Rezoning Transportation Analysis

Petition Number: 2023-080

Date	Description
8-24-23	First Review (JP)
9-20-23	Second Review (JP)

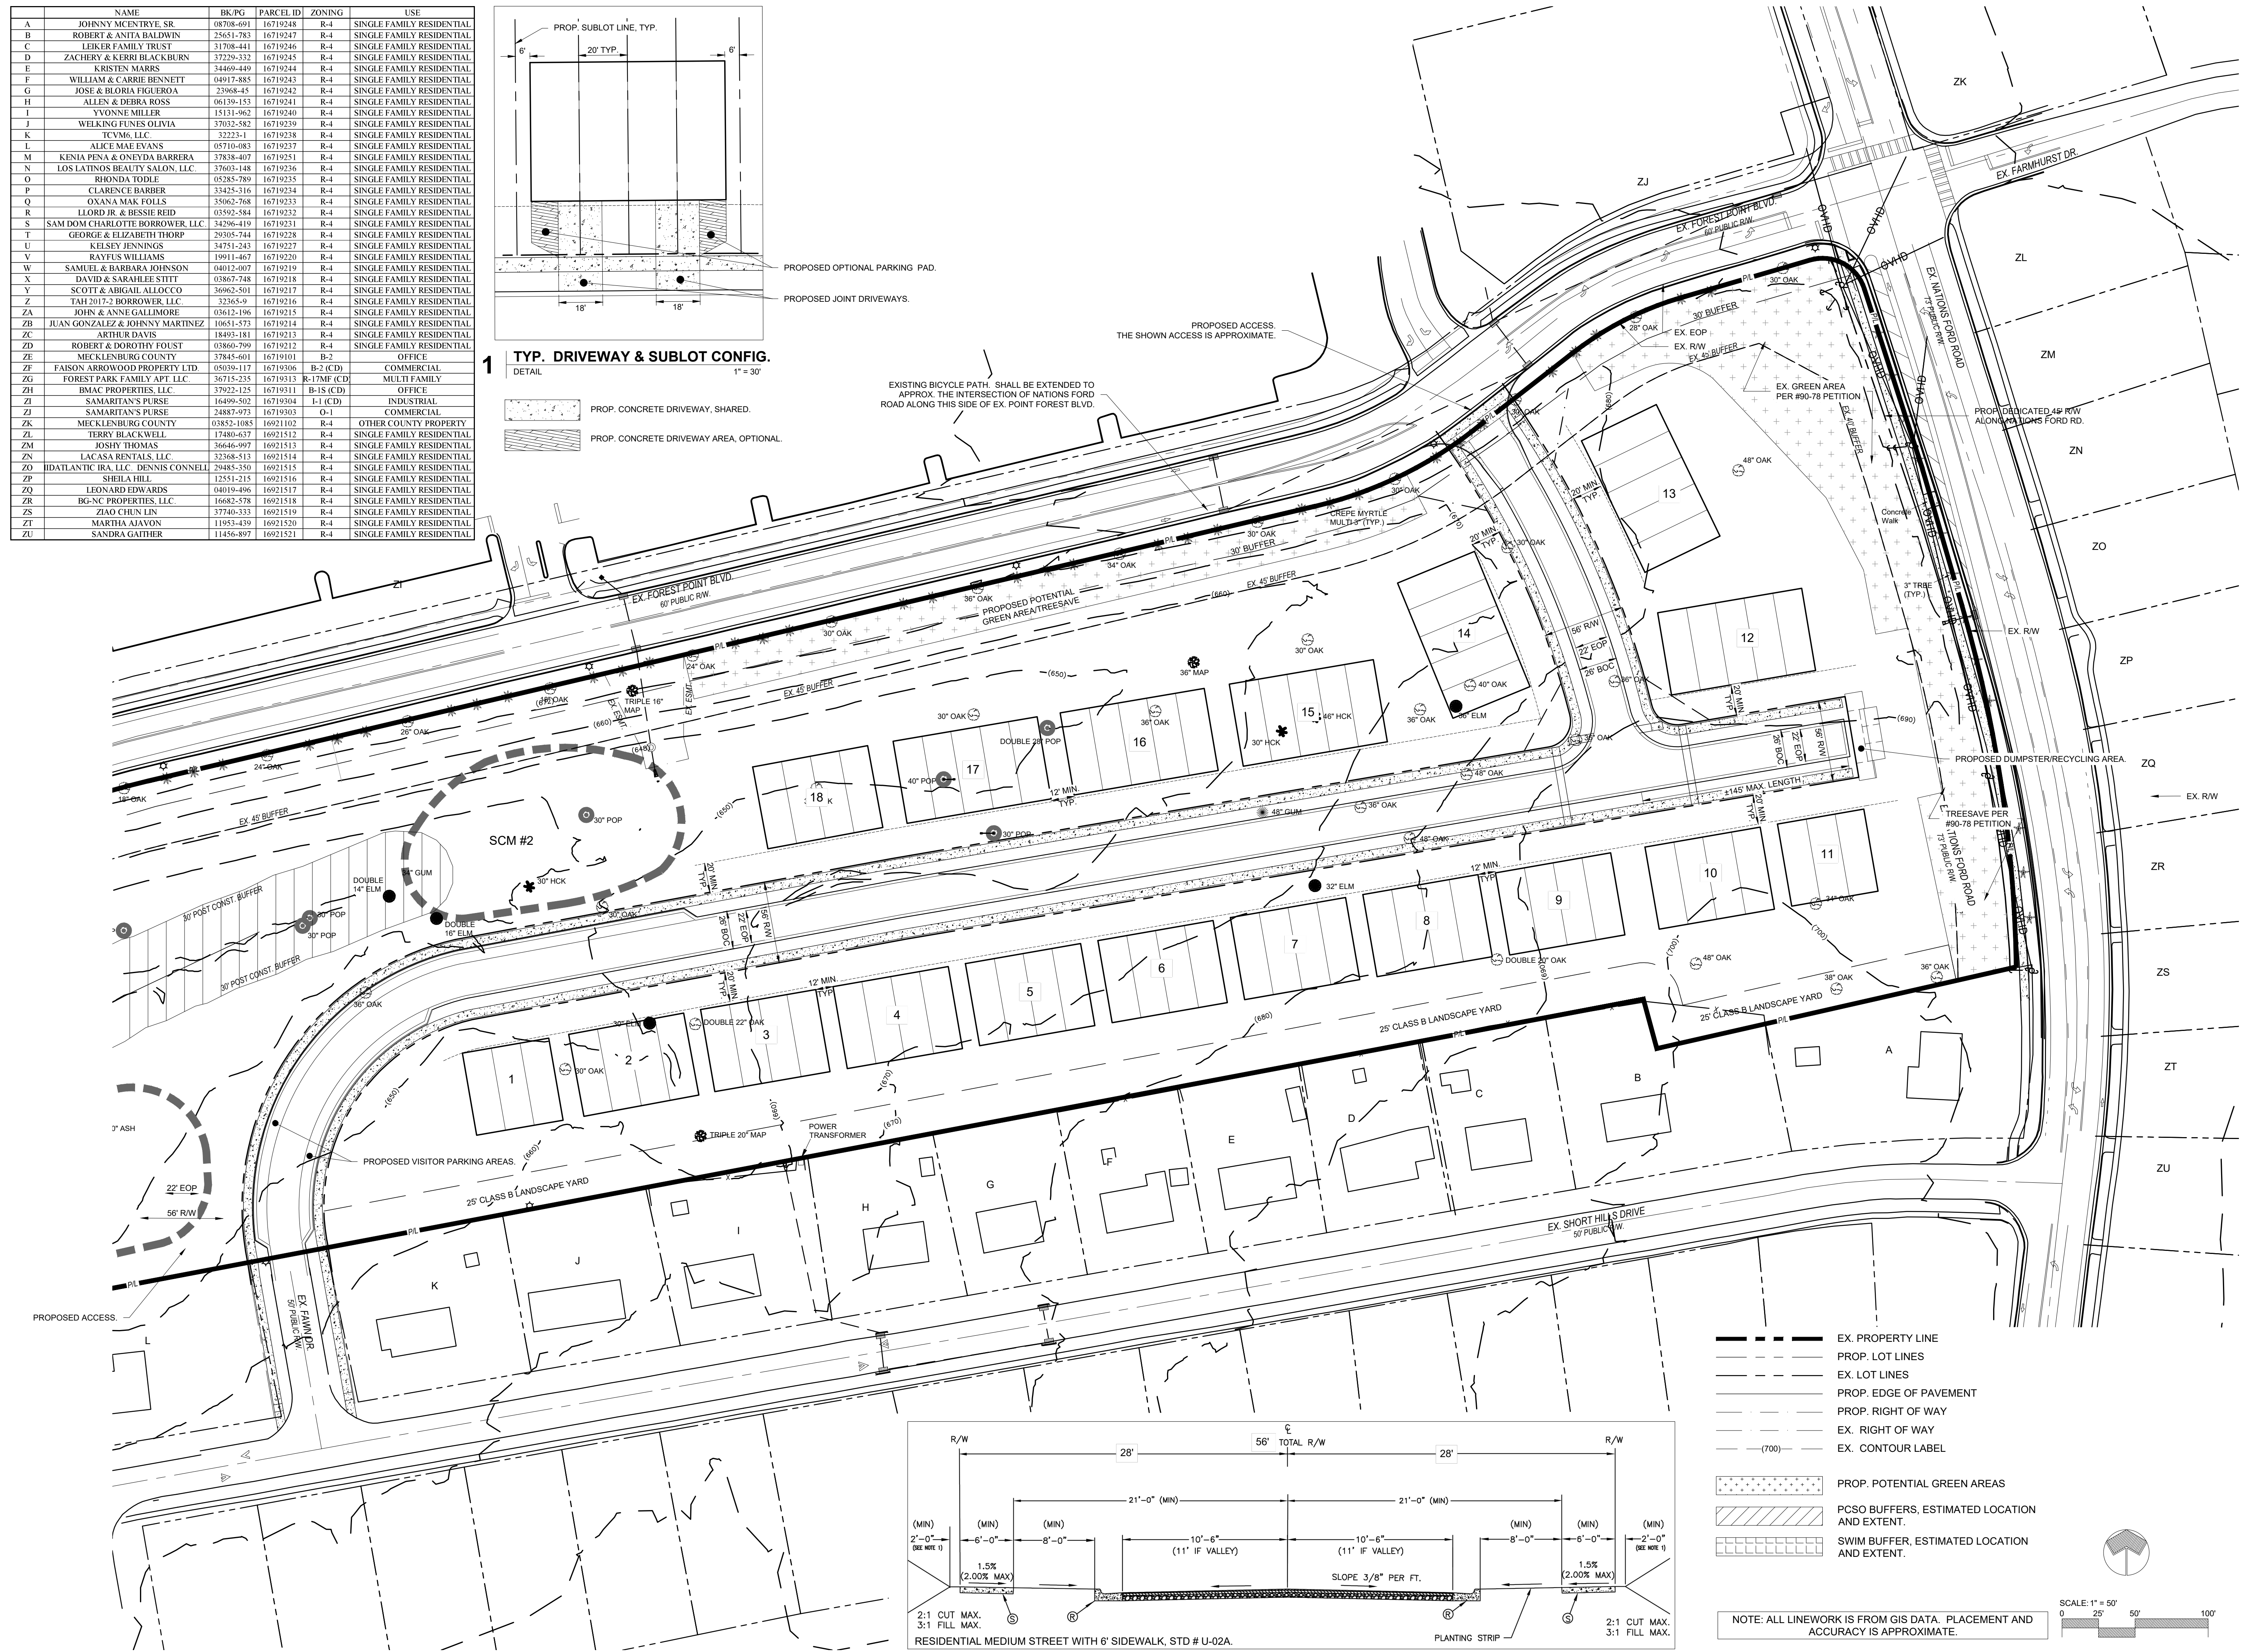
- a. **Forest Point Boulevard:** Future curb line is in the existing location
- b. **Fawn Drive Extension:** Street typical section is local residential medium (U-02B) with 58' of right-of-way.

- c. **Proposed Public Street:** Cross section is local residential medium (U-02B) with 58' of right-of-way.

Clarifying Comment 9.20.23: U-02B should be used based on the zoning district N2 and street type.

Label and dimension the curb and gutter from the centerline for each road on the site plan.

3. Revise site plan and conditional note(s) to commit to construct an 8-foot planting strip, and 8-foot sidewalk on Forest Point Boulevard per UDO 32.7(D)(b)(ii); 8-foot planting strip, and 8-foot sidewalk on both sides of Fawn Drive Extension per UDO 33.3(D); and); 8-foot planting strip, and 8-foot sidewalk on both sides of Proposed Public Street per UDO 33.3(D). The site plan shall label and dimension both items from the back of curb and gutter or edge of pavement.
